OXFORDSHIRE COUNTY COUNCIL'S RESPONSE TO CONSULTATION ON THE FOLLOWING DEVELOPMENT PROPOSAL

Application no: 22/03883/F

Proposal: Development of 96 Dwellings (50% affordable housing), extension to Bicester Road Cemetery with associated access (from Bicester Road), open space, landscaping and infrastructure

Location: Land North Of 66 And Adjacent, Water Eaton Lane, Gosford

Drawing:  
Bike Store 01

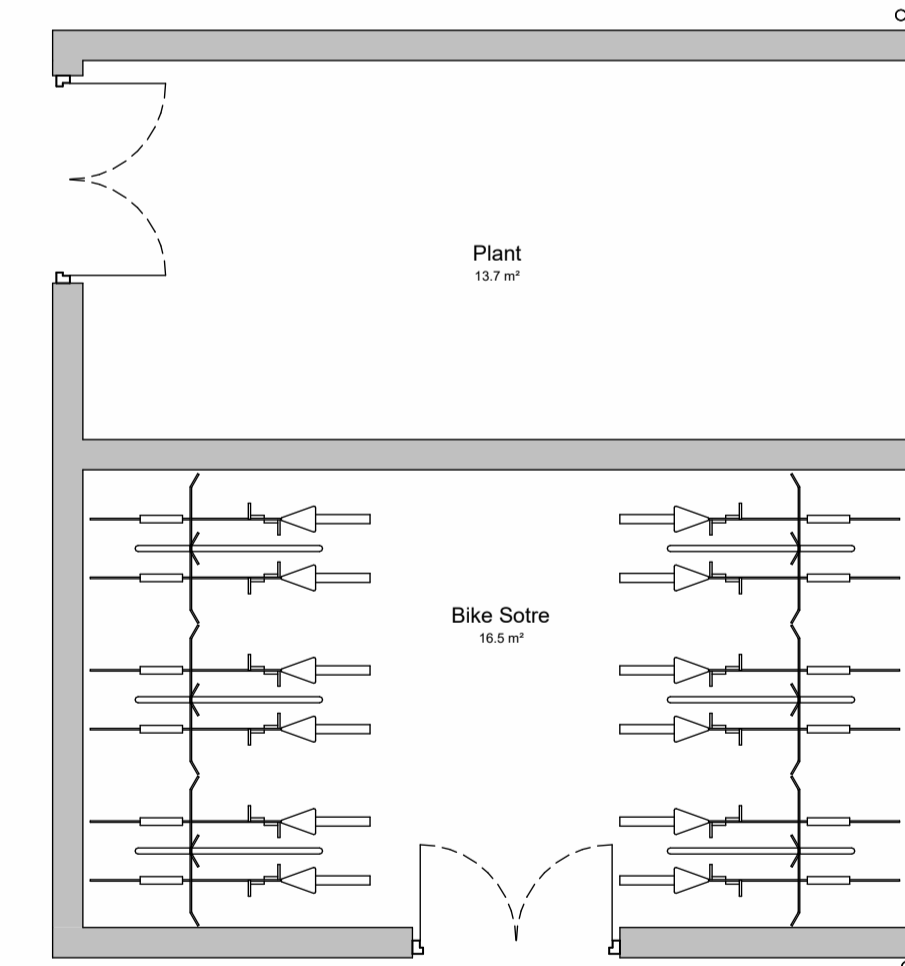
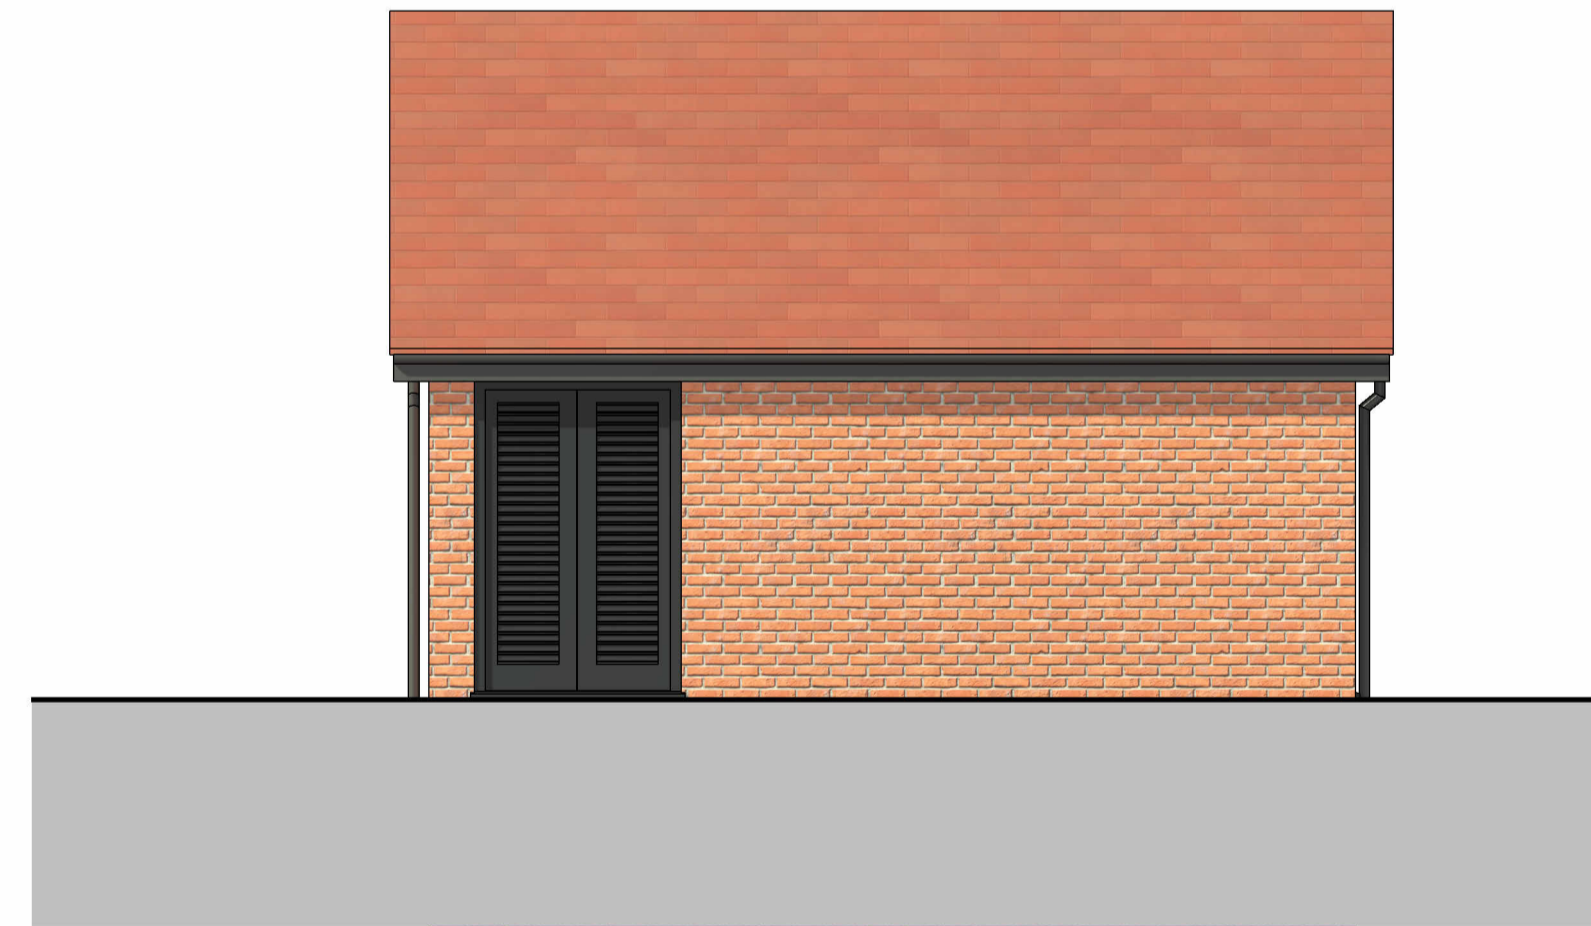
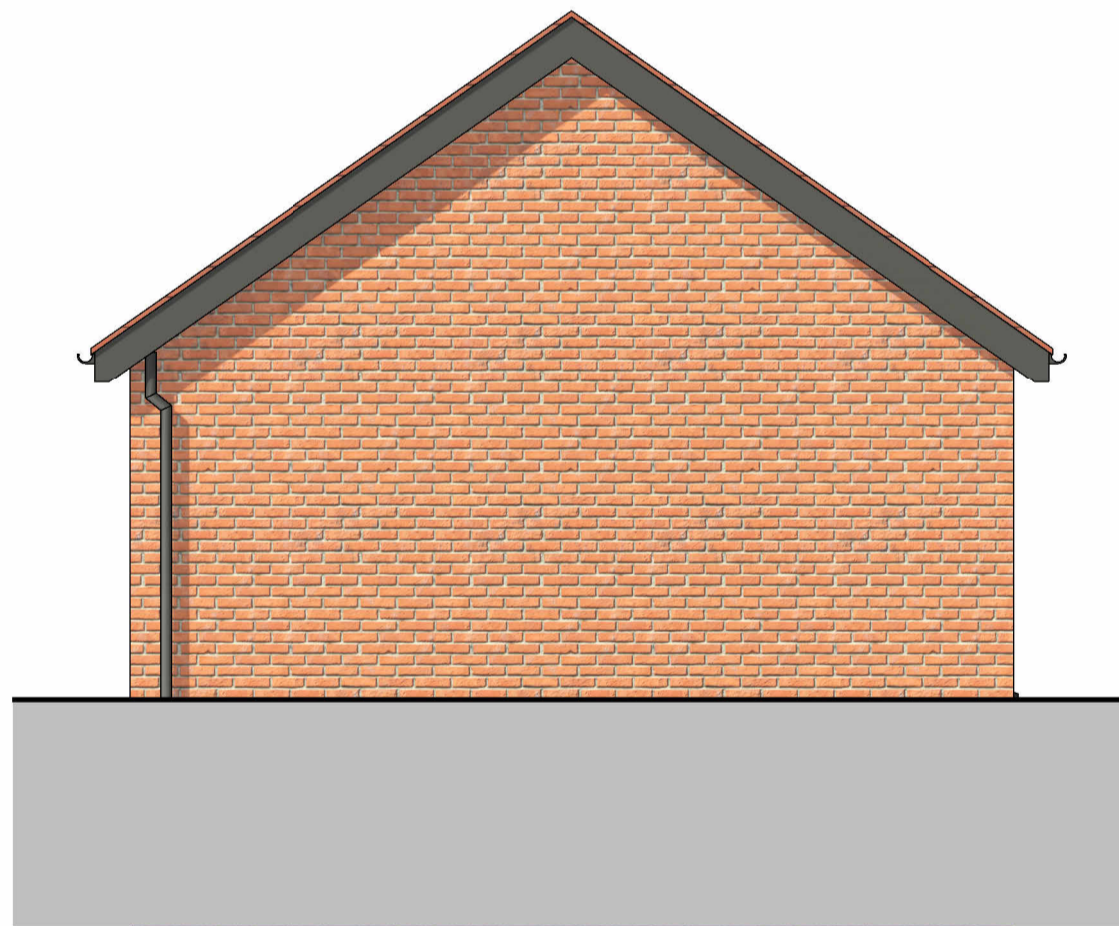
Cycle Parking - Para 2.28 asserts that cycle parking has now been amended in accordance with the HA's comments. While the willingness has been expressed that *the*

increase in cycle parking has been achieved by increasing the available cycle parking stands in the bike storage area, this provision must be shown on plans. For this, I expect to see revised plans (including apartment block plans) supporting this claim that bike storage facilities have now been increased. **(Reason for objection)**
